Householder Proforma

Application Ref: 2021/0742
Address: 18 Bank End Avenue, Worsborough Dale, Barnsley, S70 4QR
Neighbour Representations: No
Consultations None
Property Description: the semi detached red brick built dwelling is located in a purely residential area of similar styled properties.
The property is located is a triangular shaped plot which narrows to the rear and currently benefits from a pre-fabricated detached garage located forward of the principle elevation.

Proposed Extension: erection of a two storey side extension
UDP Designation: Housing Policy Area
Local Plan Designation: Urban Fabric
Conservation Area: No
Relevant History: N/A
Acceptable in Principle: Yes

Title
**PROPOSED FLOOR PLANS,
ELEVATIONS & SECTION**

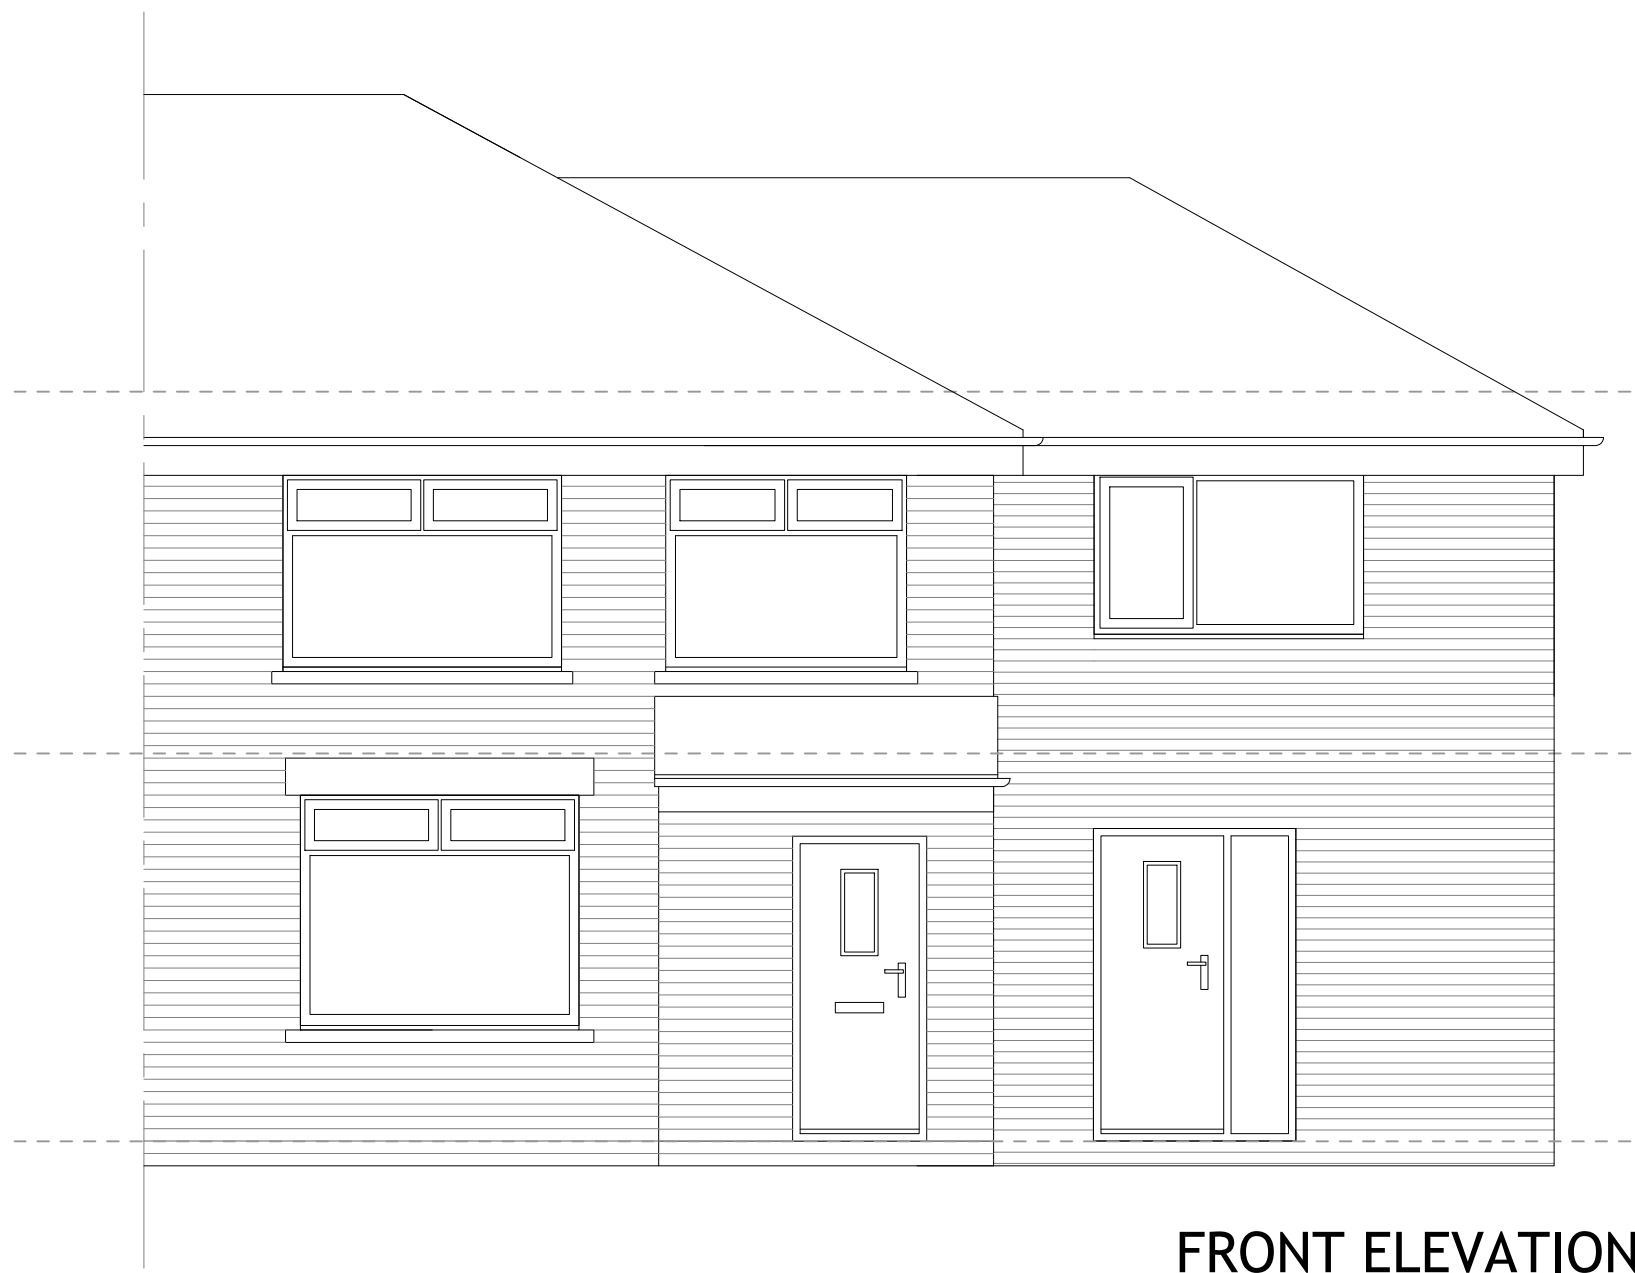
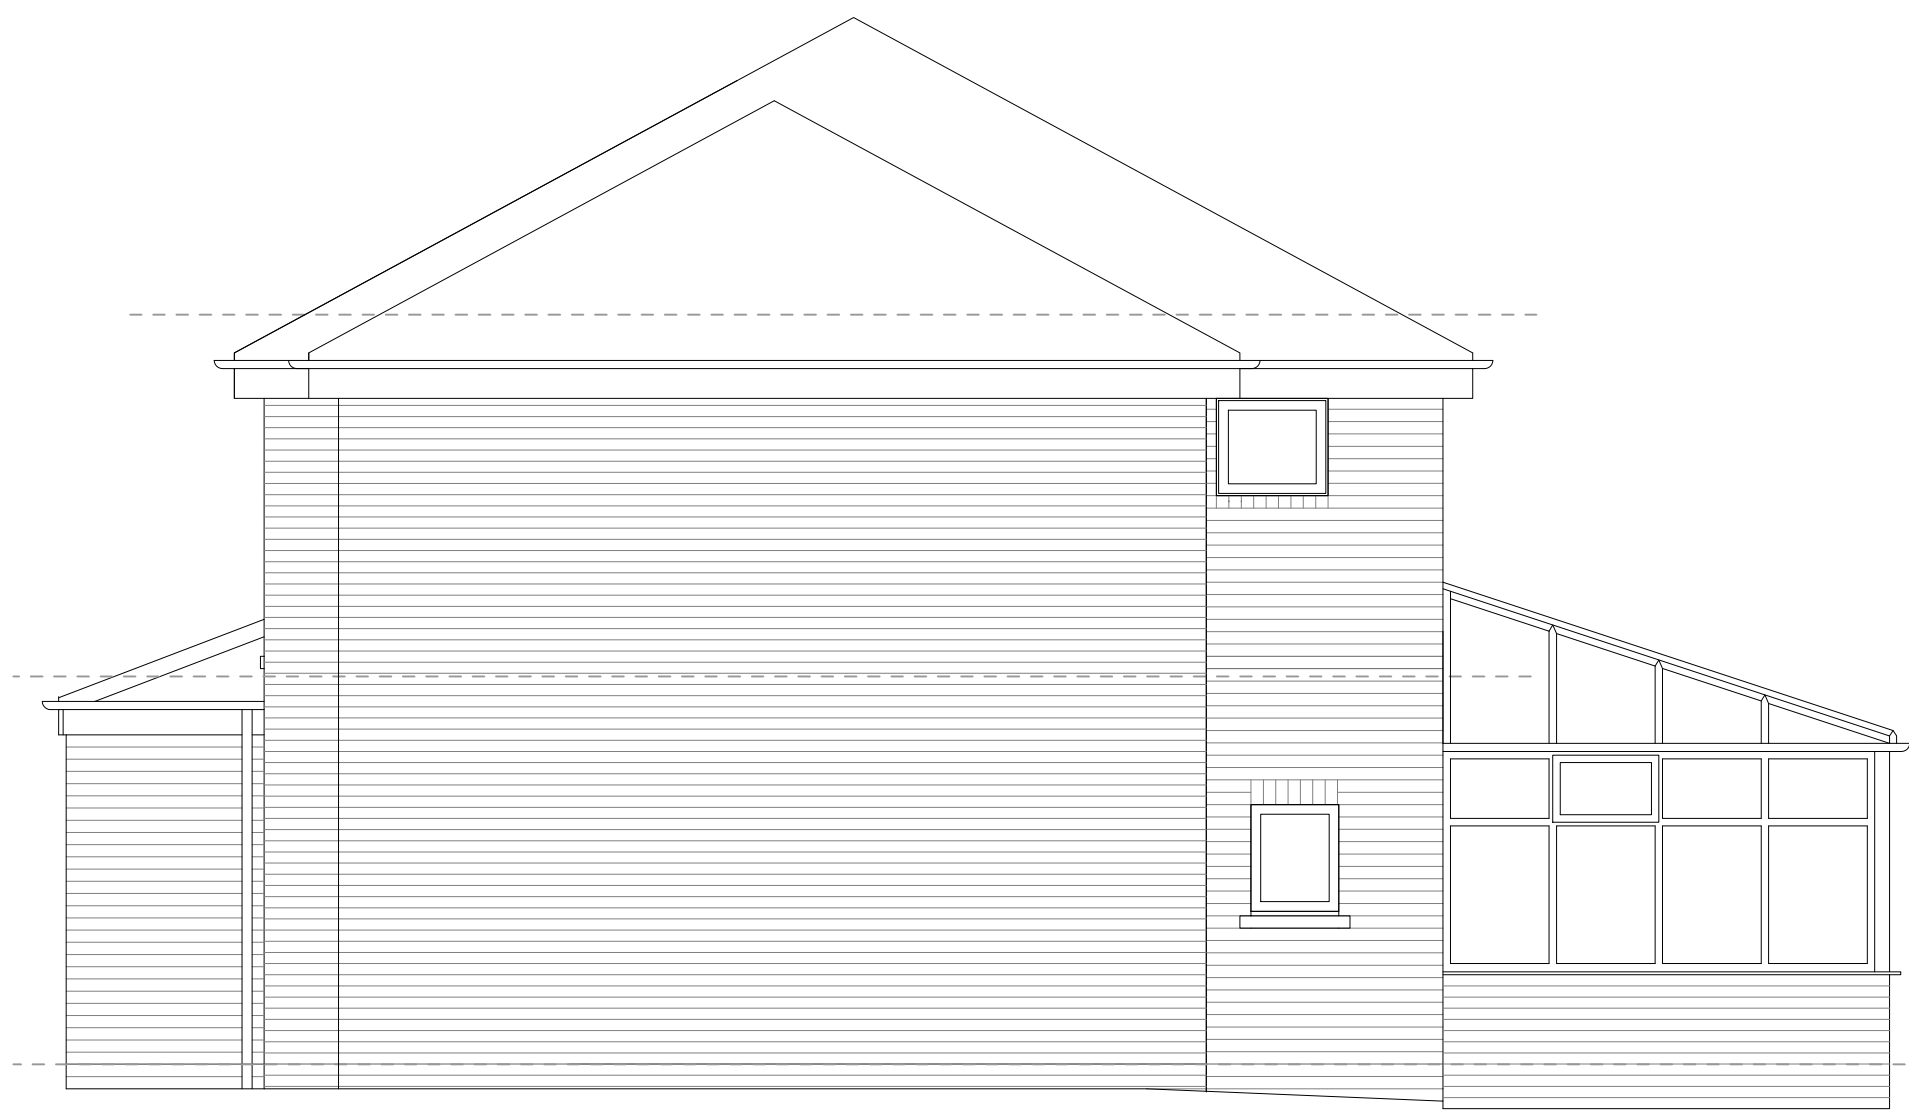
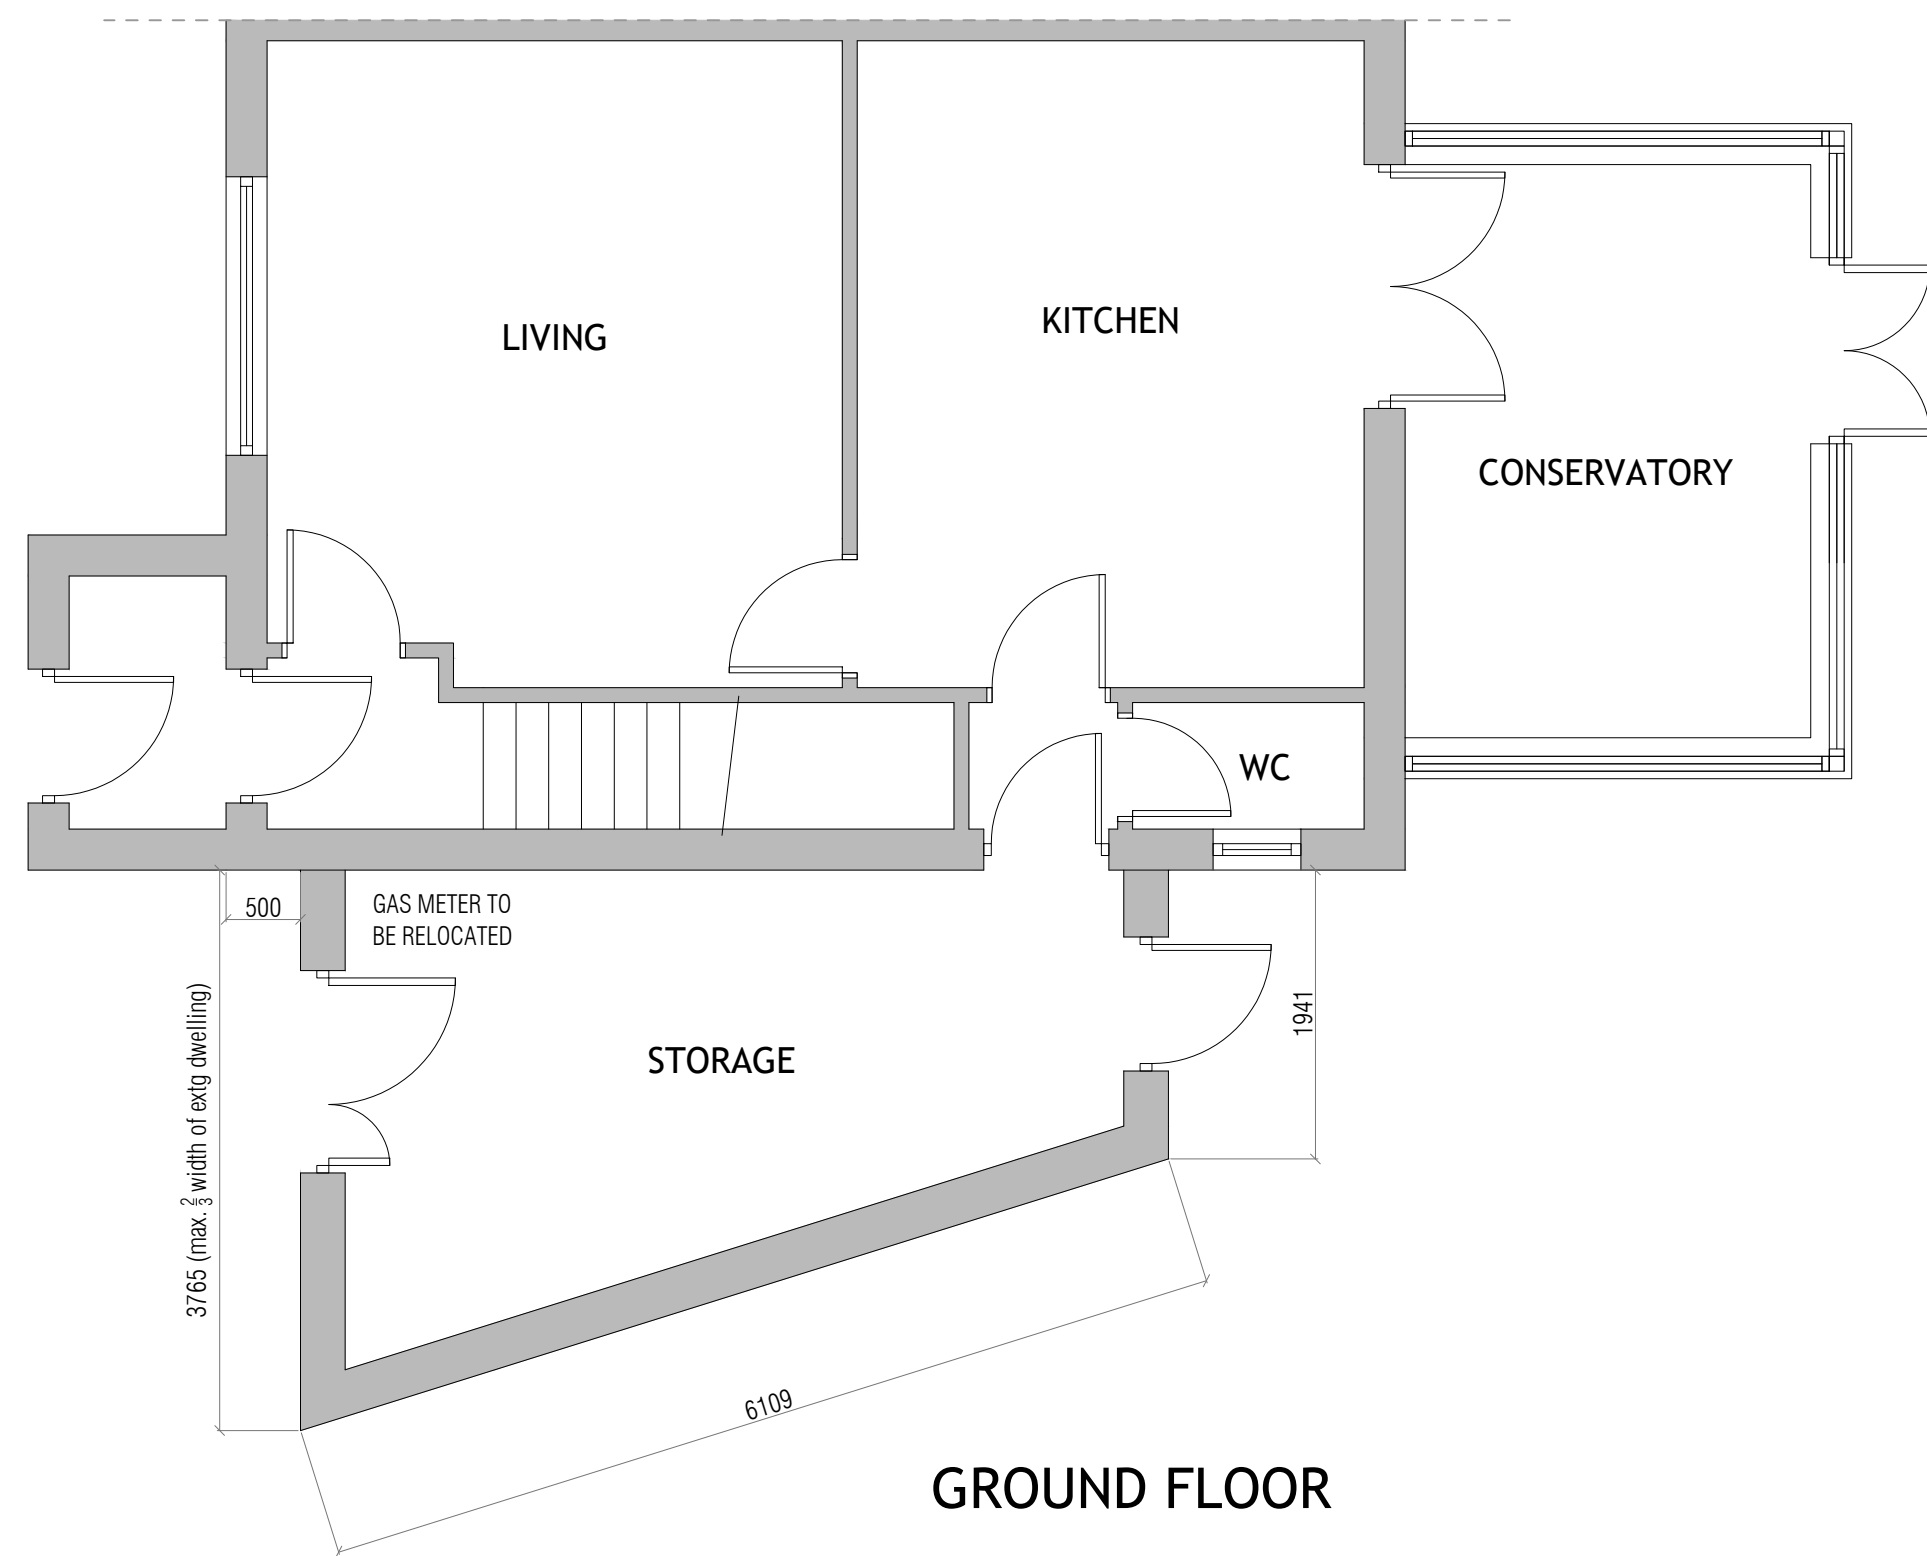
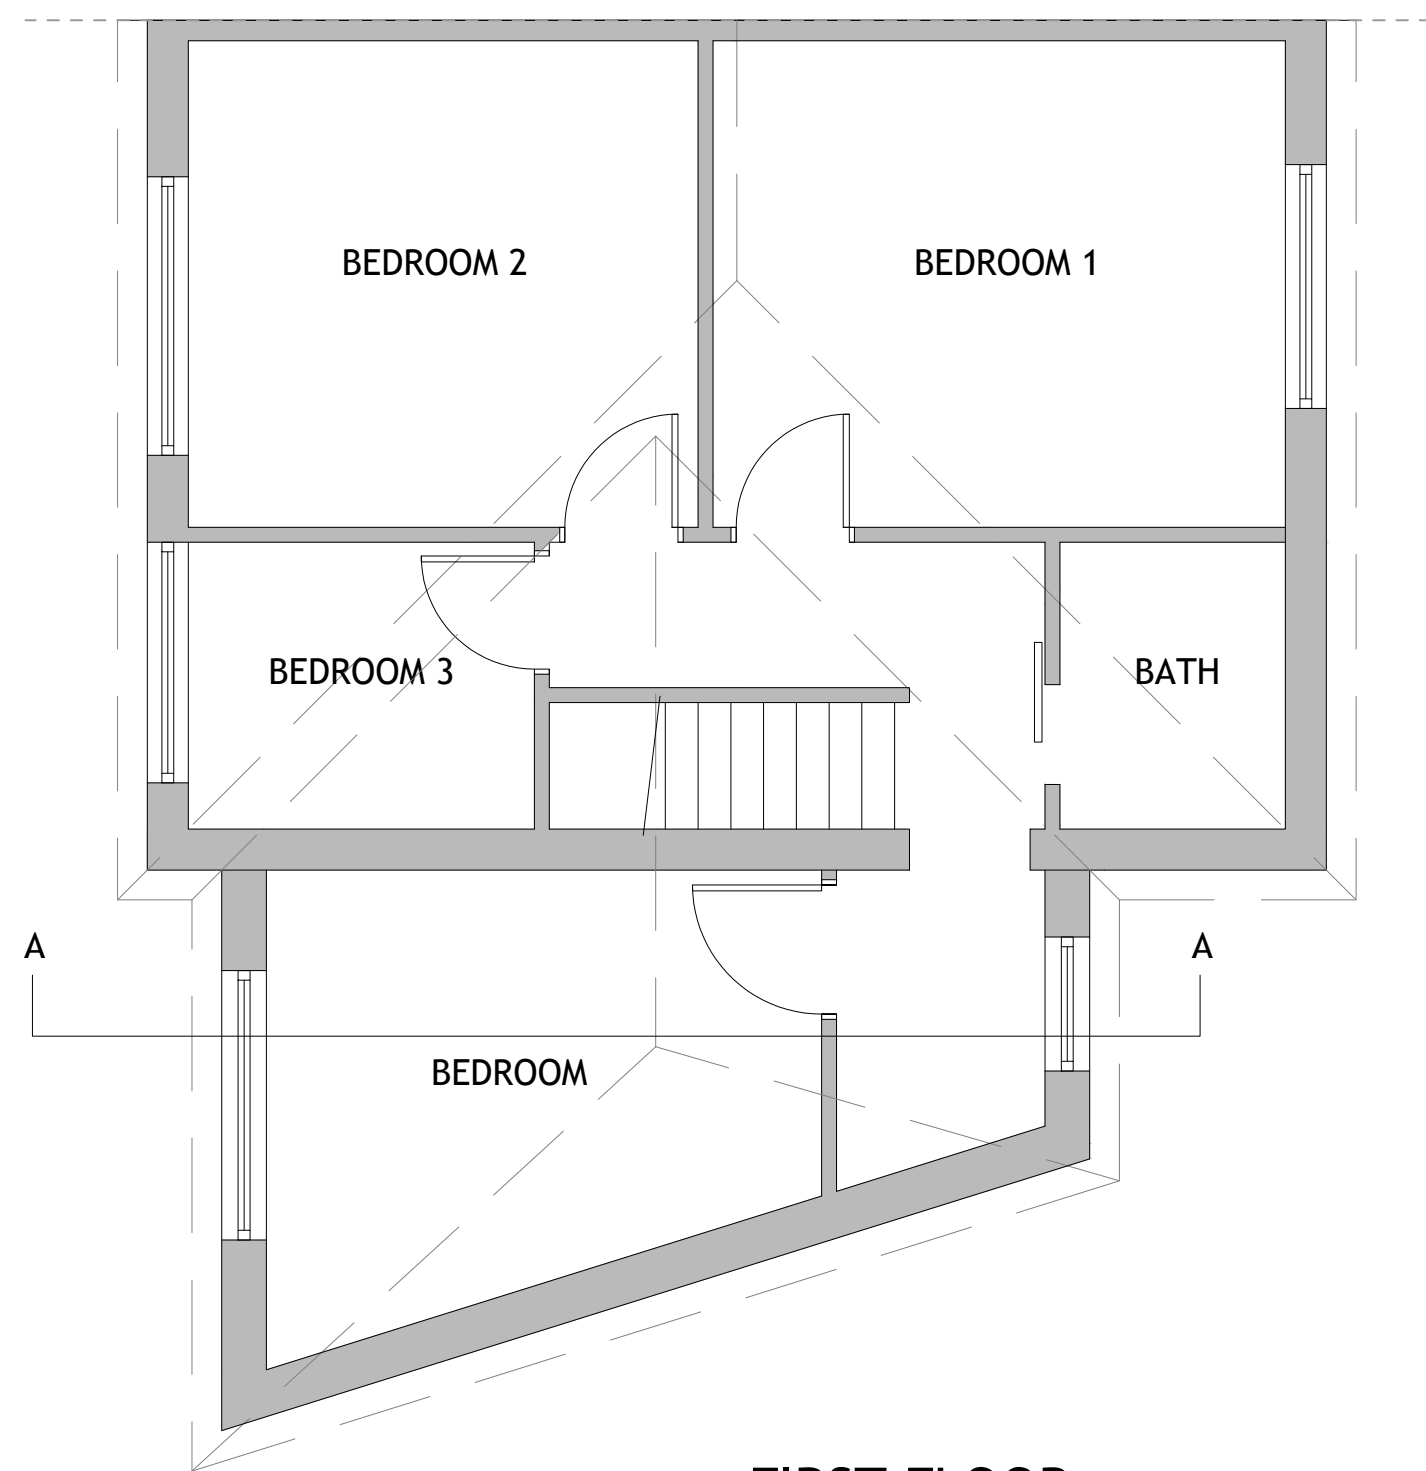
Yes / No (include comment if required)
Single Storey	
1. set back	
Two Storey / First Floor	
2. set back / set down (500mm minimum)	Yes: 500mm
3. less than 2/3 the width of the original dwelling	Property width - 5.6m Extension width allowed - 3.7m Extension width proposed - 3.7m at front reducing to 1.9m at rear
All

4. roof design corresponds to existing	Yes; hipped roof extension on hipped roof property
5. windows / doors of a similar design / proportion	Yes
6. habitable room windows on the side elevation	No

7. materials to match	yes
8. neighbouring property extended to side or windows?	No extension at neighbouring property but there is a window on the side elevation, however this window is serving a landing and therefore is not classed as a habitable room window.

9. Any change to parking or access?	No; dwelling changing from 3bed to 4bed no additional provision required, improving situation with a driveway 5.5m in length following the removal of a pre-fabricated garage which is located forward of the principle
